**From:** David Rippingill <davidrippingill@designcollaborative.com.au>  
**Sent:** Thursday, 23 April 2015 11:27 AM  
**To:** Simon Truong  
**Cc:** James Lidis  
**Subject:** Further Submission to SSD 6724 - 60-78 Regent Street, Redfern

We have reviewed the Applicant's 'Response to Submissions, prepared by JBA Planning and dated March 2015. Many of the concerns of our client remain unaddressed. We reiterate those below which we consider remain outstanding.

SITE SECTION

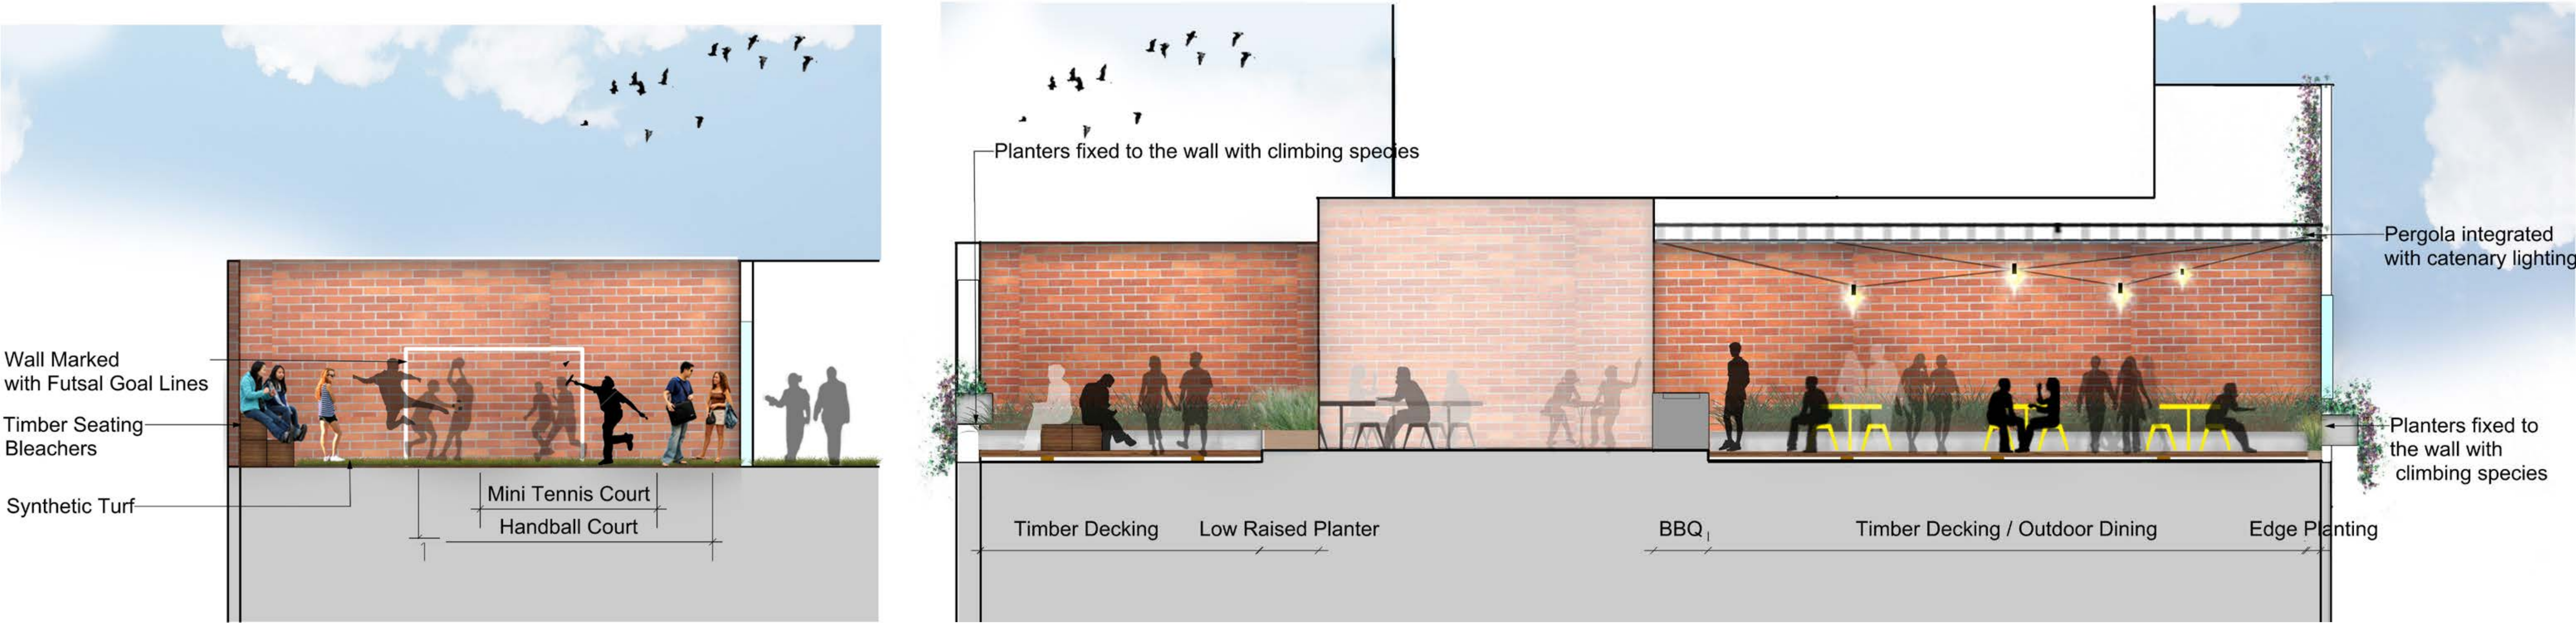
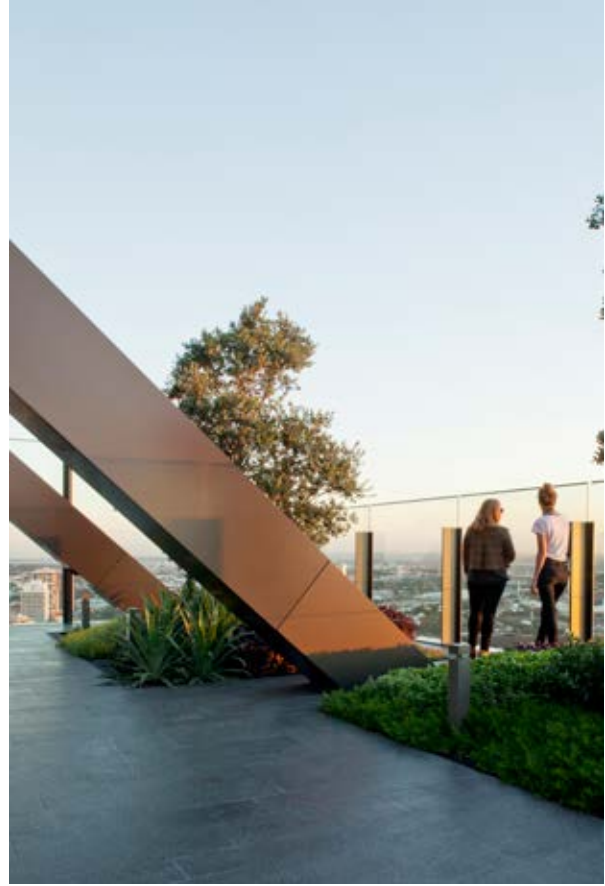
Furthermore, no additional information has been provided with respect to the potential for lighting impacts to lower floor apartments of our client’s site. Whilst the Applicant has precluded the use of the courtyard after 10pm, outside of day-light savings time it would be sufficiently dark from 6pm to require the use of flood lighting for the ball games area as noted on the plans.

- No submission regarding or light impact study has been provided despite the clear potential for adverse impact from the outdoor games area adjacent to and below residential dwellings;
